# Rezoning Transportation Analysis

Petition Number: 2021-081

Date	Description
08-02-21	First Review (LH)
08-26-21	Second Review (BKB)
09-28-21	Third Review (BKB)

ALEXANDER VILLAGE MAIN DRIVE EXTENSION (SECTION 'B')
NOTE: LOCAL OFFICE/COMMERCIAL WIDE STREET (CLDSM U-05*)
SCALE: 1"=10'

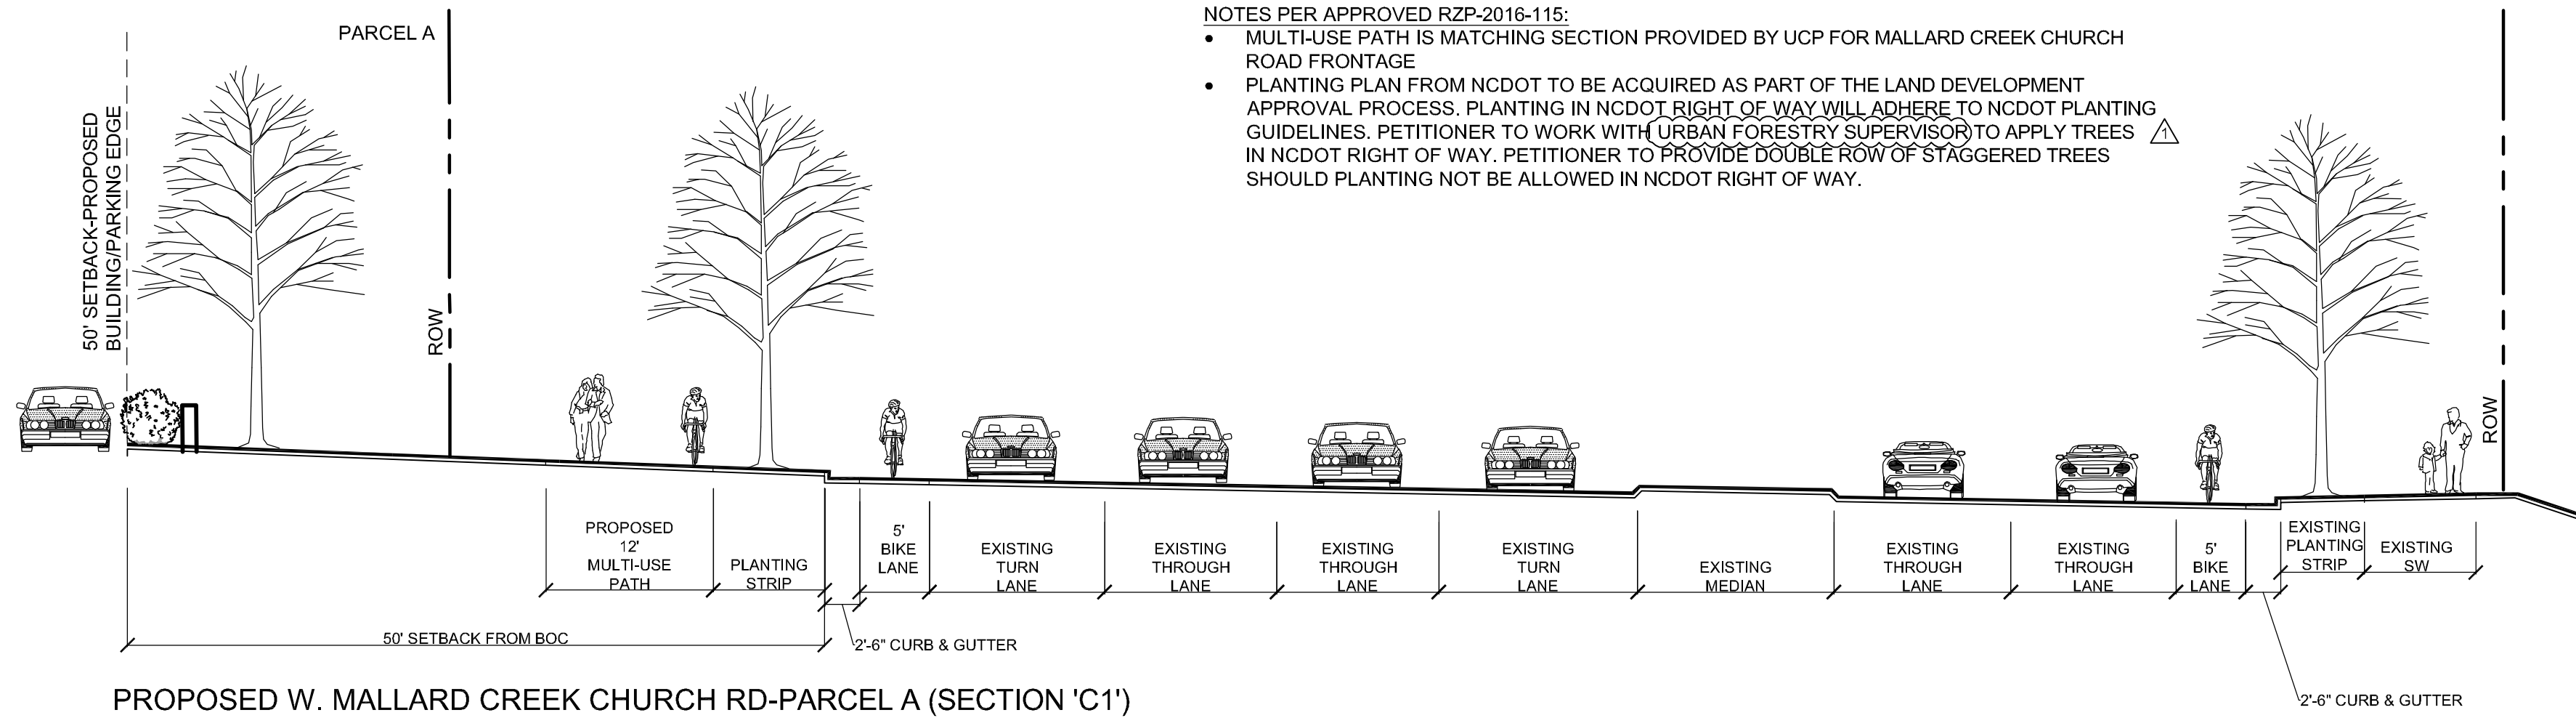
The site is located adjacent to West Mallard Creek Church Road, a State-maintained major thoroughfare, Senator Royall Drive, a City-maintained local street, and Alexander Village Main Drive, a City-maintained local street). A Traffic Impact Study (TIS) was approved as a part of Rezoning Petition 2016-115 and is not needed to be amended for this petition. There are multiple transportation improvements proposed by various land development projects that create further comprehensive network. The proposed improvements included Senator Royall Drive Widening and pedestrian improvements (12-foot multi-use path) in accordance to NCDOT approved roadway plans. In addition to installing a new CATS Bus Stop, 12-foot MUP will be provided along Mallard Creek Church Road, and both sides of Senator Royall Drive. Other transportation improvements with this project include an 8-foot planting strip and 8-foot sidewalk will be installed along north side of Alexander Village Main Drive as well as a right-turn lane from Mallard Creek Church Road into the site. Minor outstanding comments to update the site plan and typical section for Alexander Village Main Drive are needed to match the transportation notes.

- Update to Comments (Site Plan dated 08-16-21):** Update Note 3 for Transportation notes to reflect current bicycle and pedestrian accommodations shown in site plan and typical sections. Modify verbiage to reflect 8 foot planting strip and 8 foot sidewalk on the site's frontage of Alexander Village Main Drive (remove Senator Royall Drive from that sentence). ~~Specify 12-foot multi-use path on both sides of Senator Royall Drive.~~

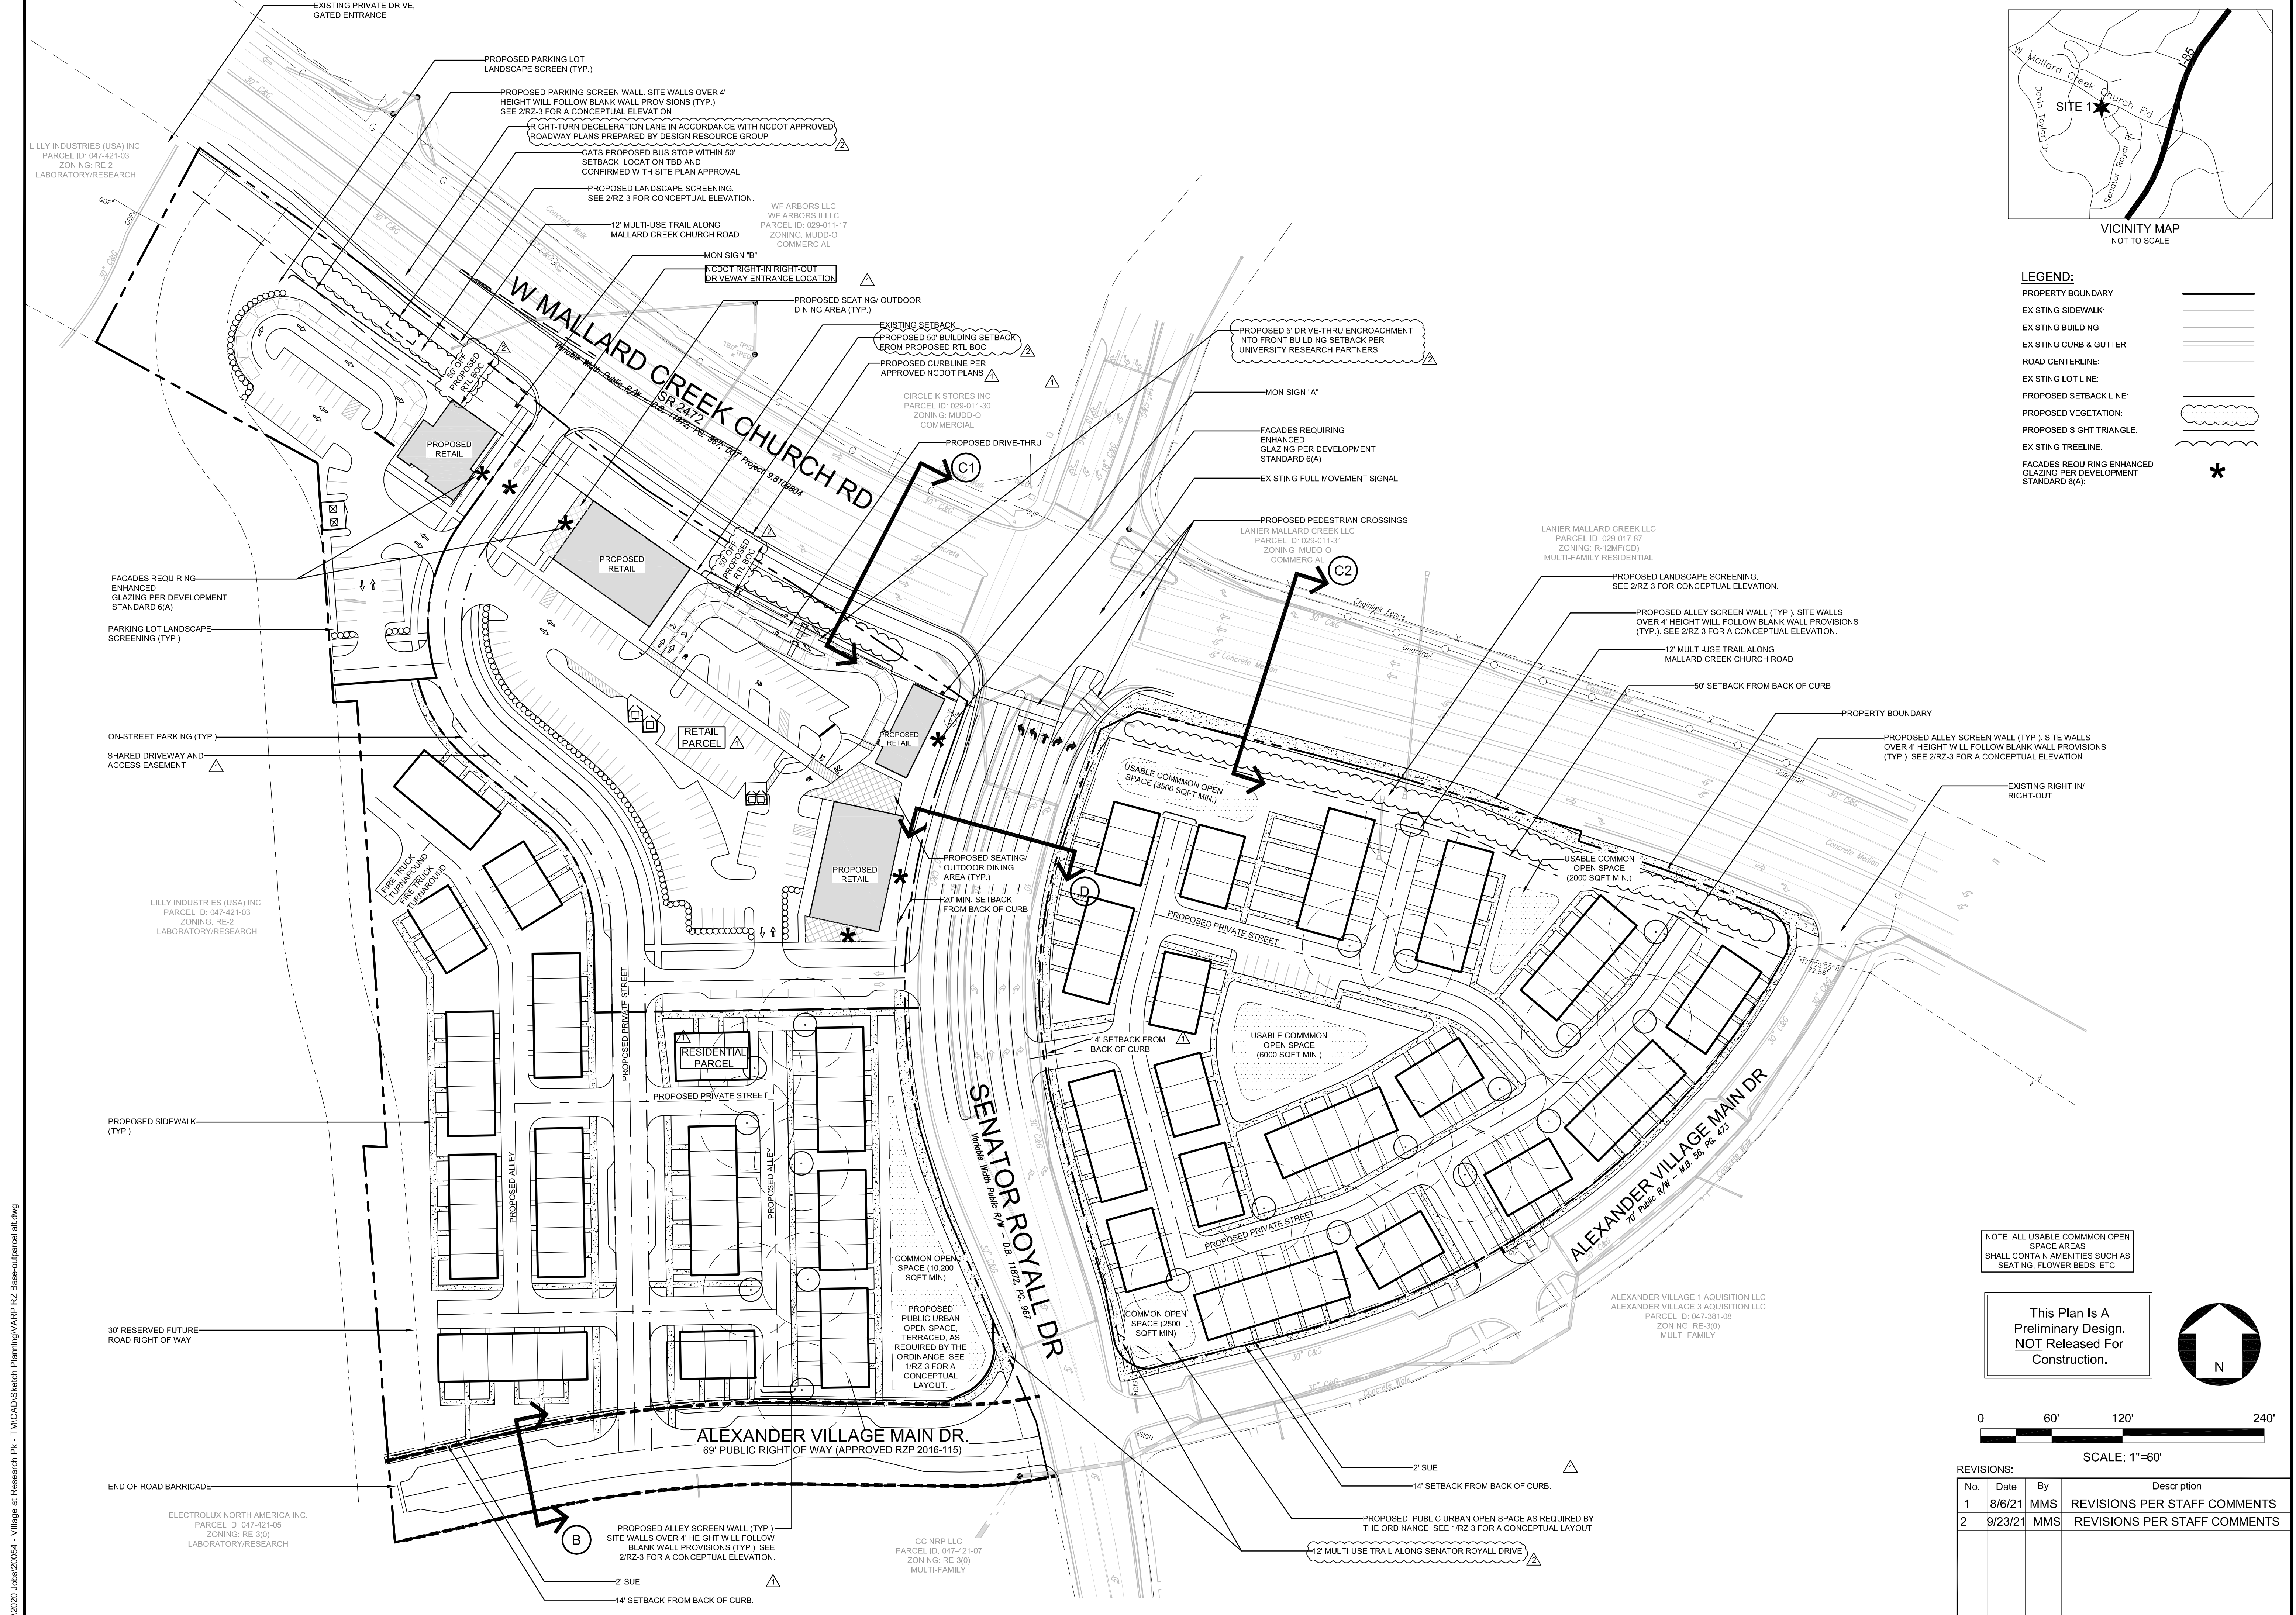
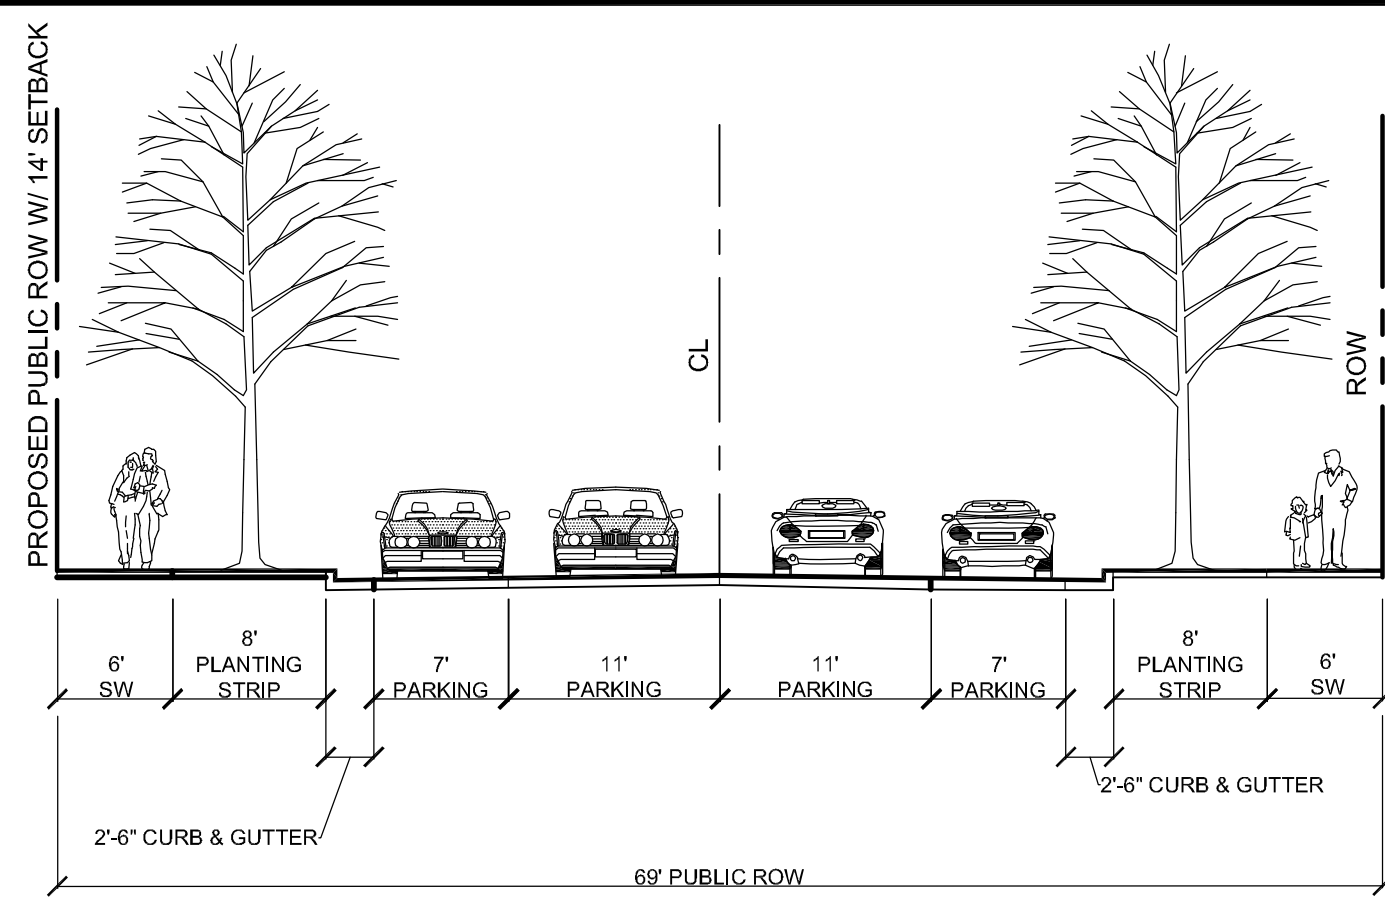
**Update to Comments (Site Plan dated 09-23-21):** Conditional note added for 8-foot planting strip and 8' sidewalk along Alexander Village Drive. Update site plan and typical section to reflect as well.
